Re: **Marysville Corporate Center**
Final BSP – PA22004
Project Number 2200444.06

In response to your plan review checklist dated December 21, 2023, we have addressed the items below, with our responses following your comments.

INDEX DATA: SEC 28-33 T 31N R 5E WM
SURVEY FOR: PACIFIC REALTY ASSOCIATES, L.P. 15908 47TH AVE NE MARYSVILLE, WA 98271
SNOHOMISH COUNTY, WASHINGTON
SHEET 6 OF 13

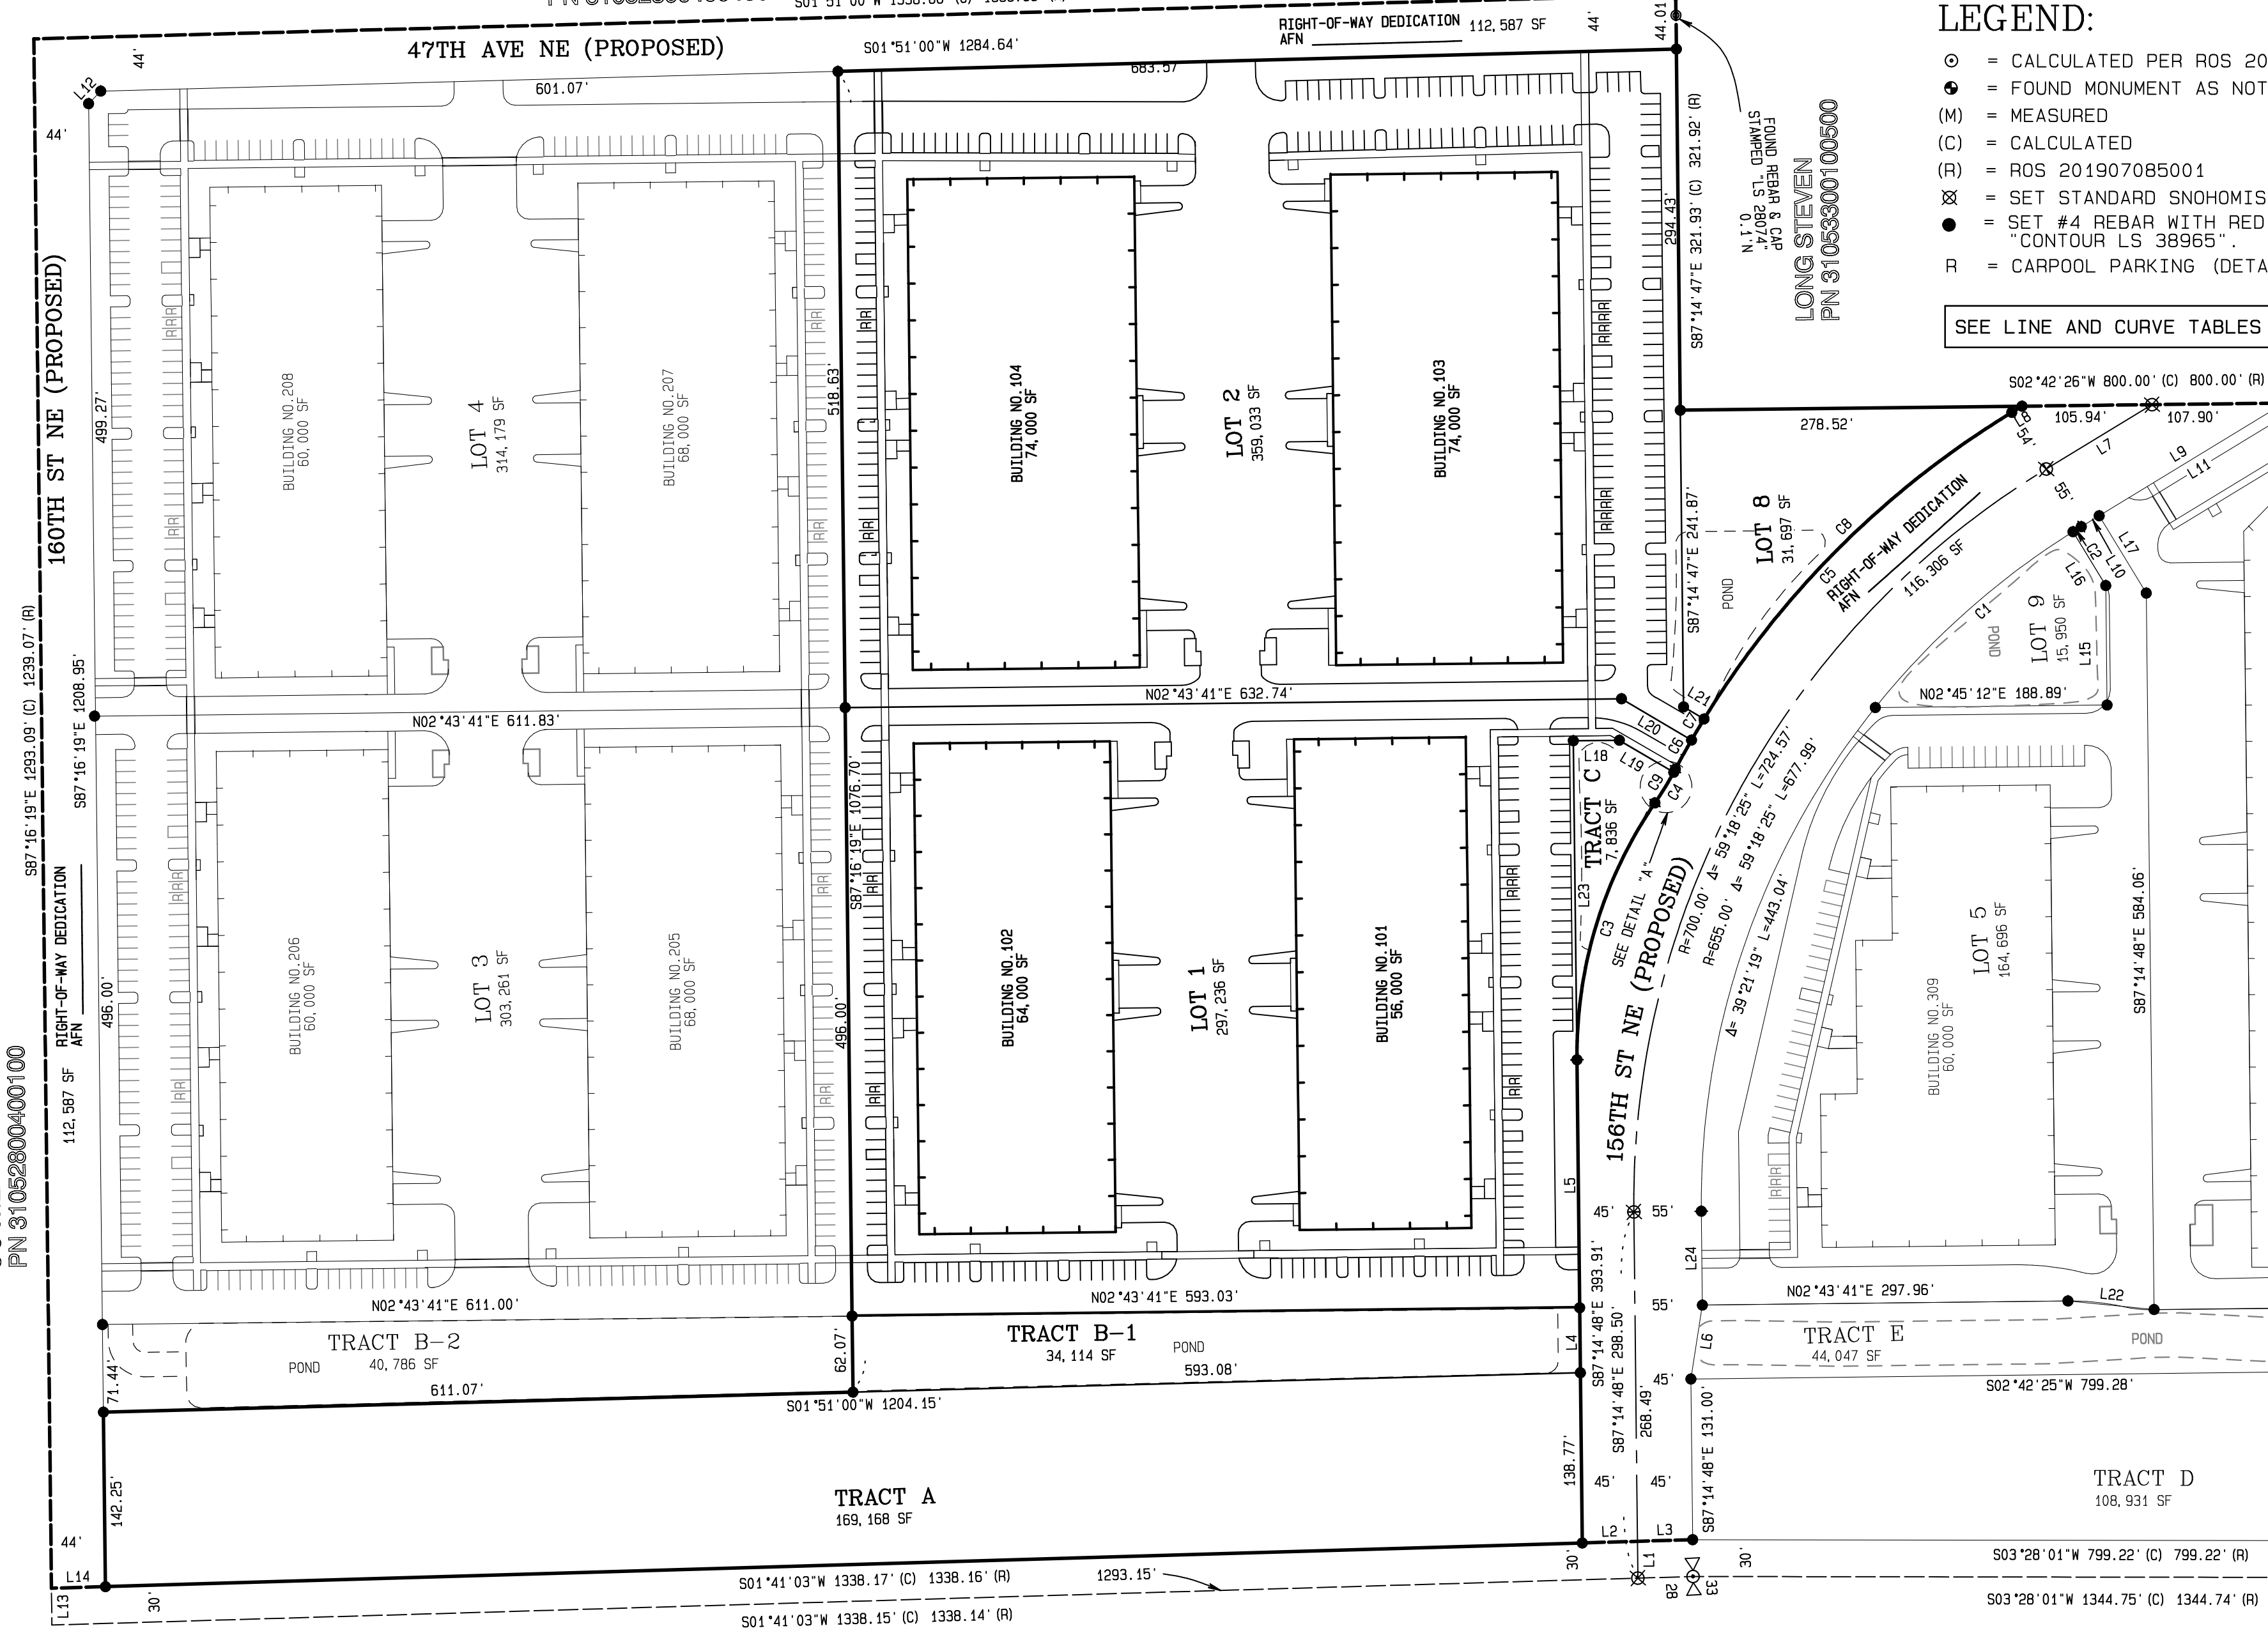
5. Sheet 6 of 13:

- a. Remove "PROPOSED IMPROVEMENT."
- b. Remove "RIGHT-OF-WAY DEDICATION AFN ."
- c. Remove 156TH ST NE (PROPOSED), and amend to read "156TH ST NE (HEREBY DEDICATED PUBLIC RIGHT OF WAY)".
- d. Remove the proposed building pads, parking areas and swale from lot 5. Only the lot lines should be shown.
- e. Remove the proposed building pads, parking areas and swale from lot 6. Only the lot lines should be shown.
- f. Remove the swale from Tract D, E, F & H. Only the tract lines should be shown.
- g. Remove reference to parking stall dimensions.

Response: All requested text has been added, removed, and amended.

INDEX DATA:	SEC 28-33 T 31N R 5E WM
SURVEY FOR:	PACIFIC REALTY ASSOCIATES, L.P. 15908 47TH AVE NE MARYSVILLE, WA 98271
SNOHOMISH COUNTY, WASHINGTON	
SHEET 7 OF 13

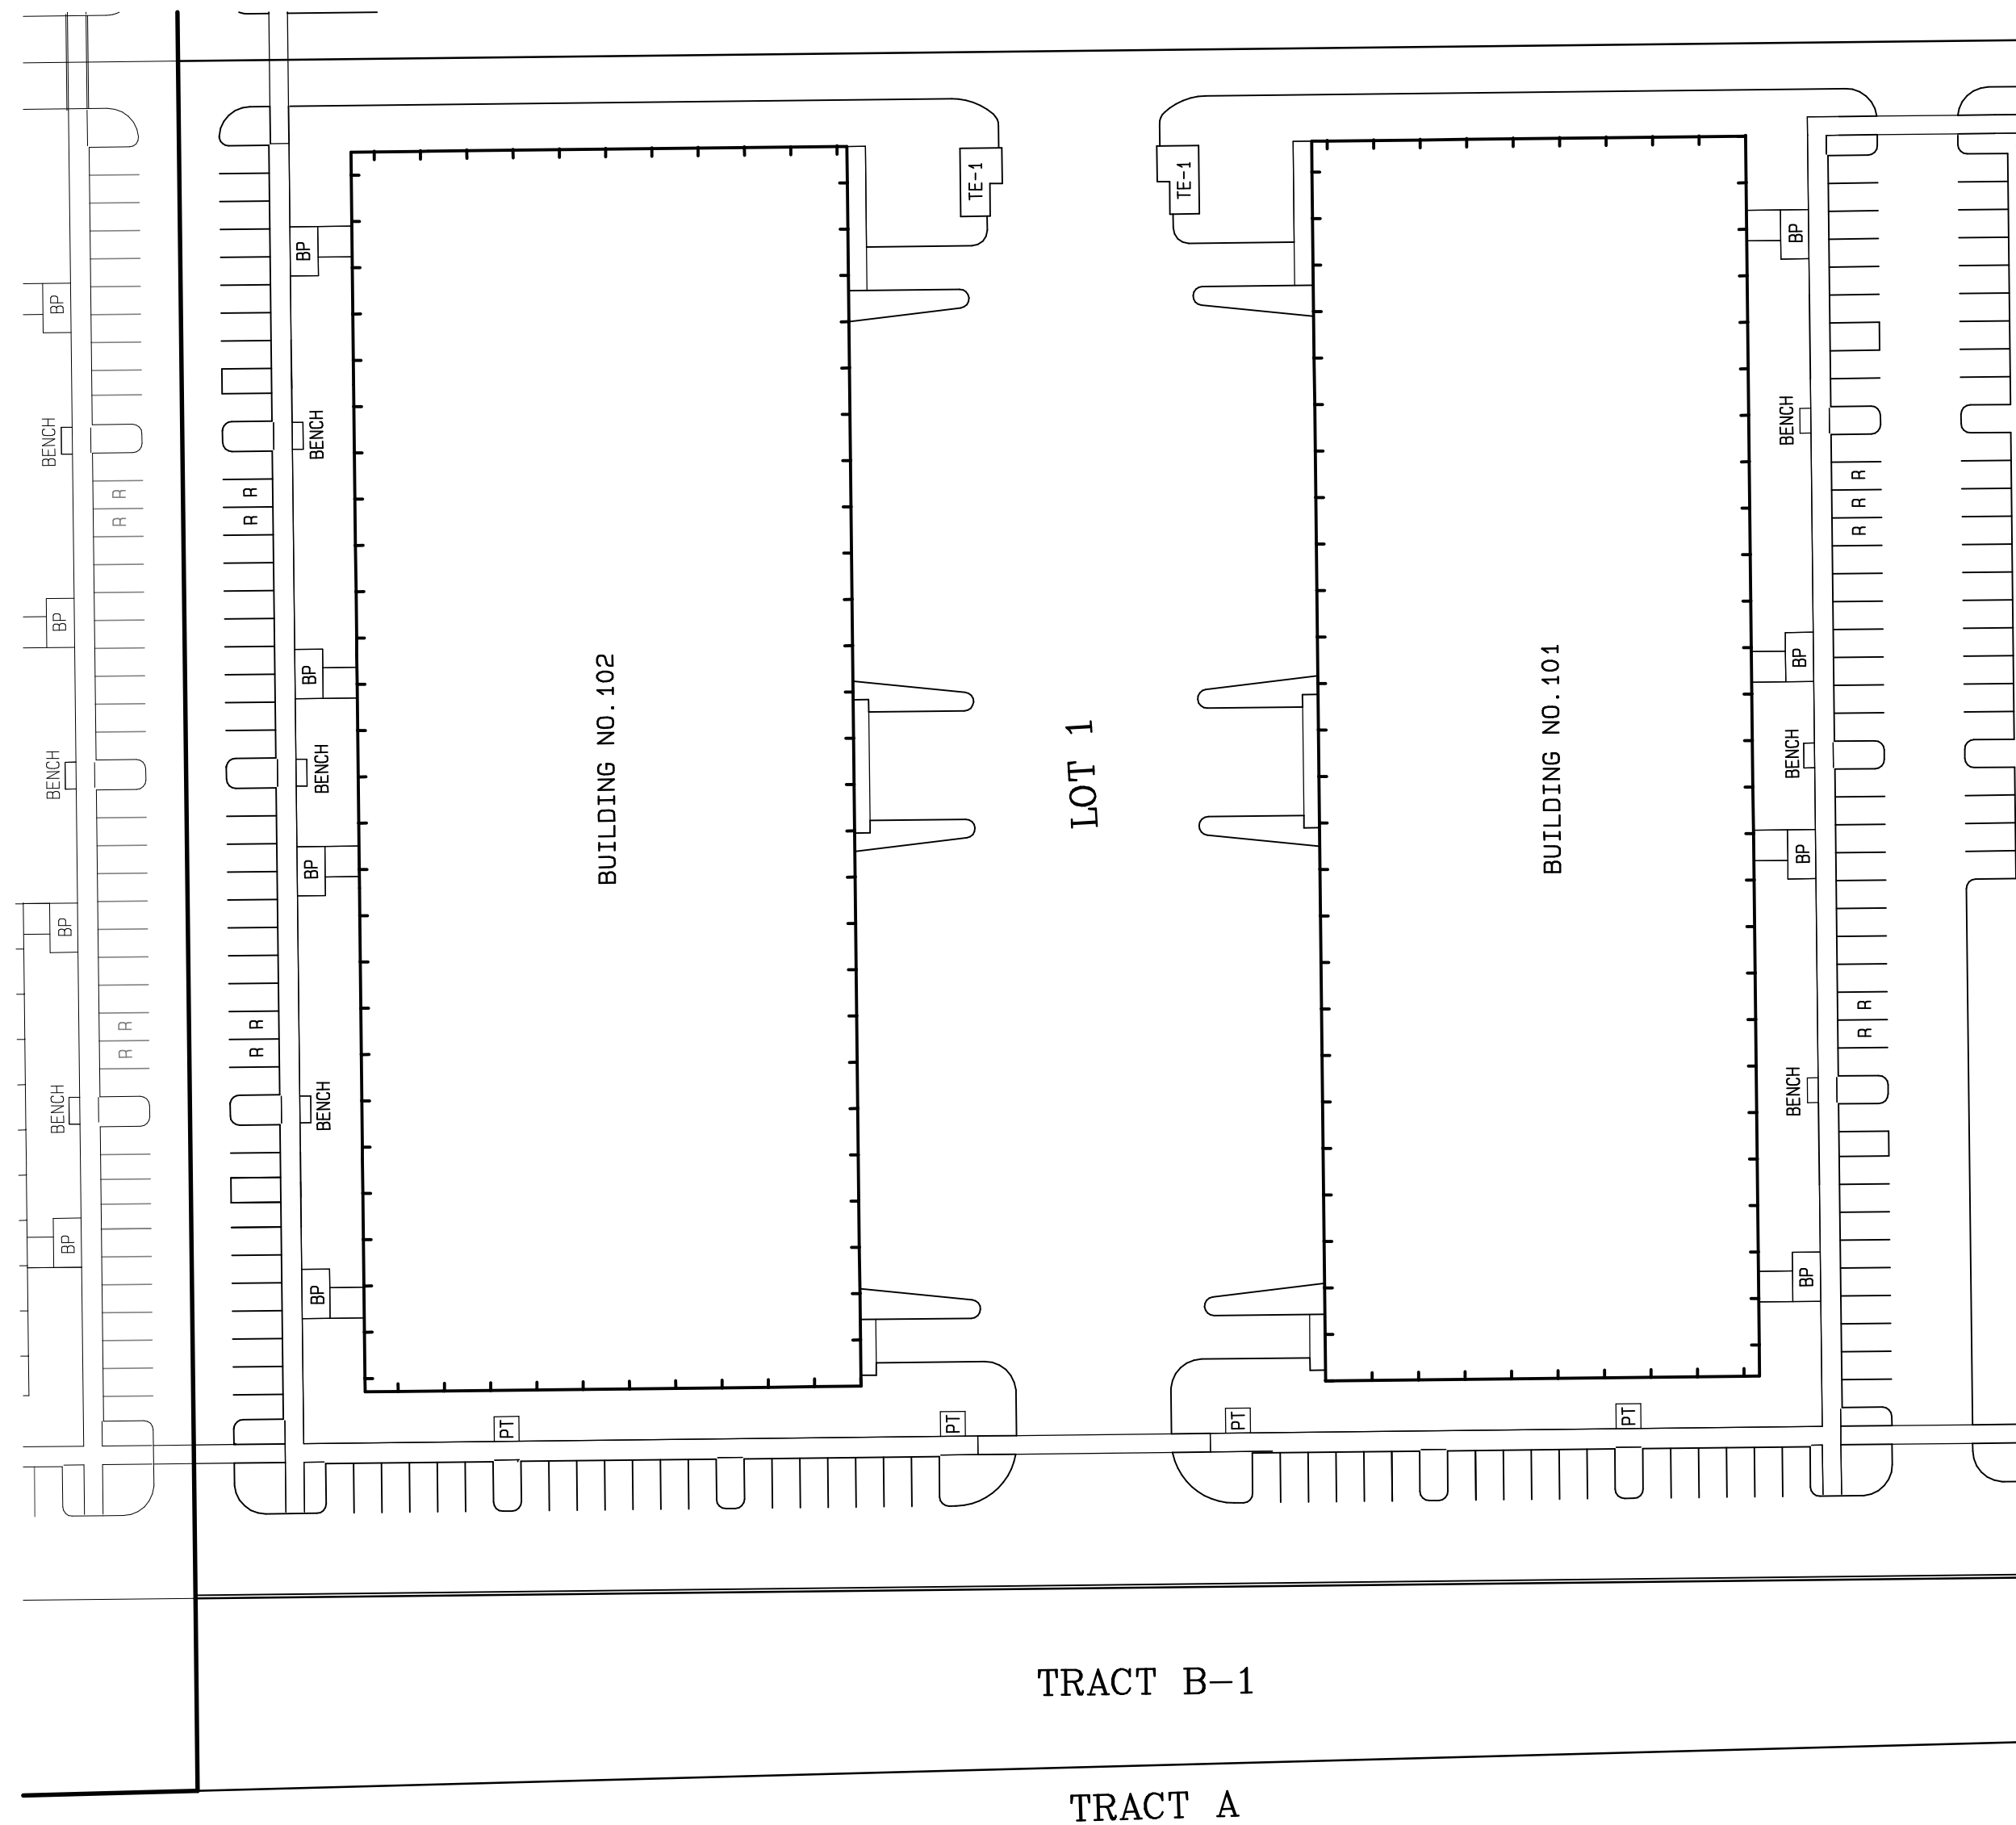
6. *Sheet 7 of 13:*
- a. Remove "PROPOSED IMPROVEMENT."
 - b. Bold the Lot Lines for all Lots and Tracts.
 - c. Remove "RIGHT-OF-WAY DEDICATION AFN _____," for both 156TH ST NE, 160TH ST NE AND 47TH AVENE.

- d. Remove 156TH ST NE (~~PROPOSED~~), and amend to read "156TH ST NE (HEREBY DEDICATED PUBLIC RIGHT OF WAY)".
 - e. Remove 160TH ST NE (~~PROPOSED~~), and amend to read "160TH ST NE (HEREBY DEDICATED PUBLIC RIGHT OF WAY)".

- f. Remove 47TH AVE NE (~~PROPOSED~~), and amend to read "47TH AVE NE (HEREBY DEDICATED PUBLIC RIGHT OF WAY)".
 - g. Remove the proposed building pads and parking areas from lot 1. Only the lot lines should be shown.

- h. Remove the proposed building pads and parking areas from lot 2. Only the lot lines should be shown.
 - i. Remove the proposed building pads, parking areas and swale from lot 5. Only the lot lines should be shown.

- j. Remove the swale from Lot 4. Only the lot lines should be shown.
 - k. Remove the swales from Tracts B, C, D, E, F & G. Only the tract lines should be shown.

- l. Remove reference to parking stall dimensions.

23. *Detail "A" on sheet 7 of the BSP map is incorrectly labeled C19. This should read C9.*

Response: All requested text has been added, removed, and amended.

Response: Label has been corrected.
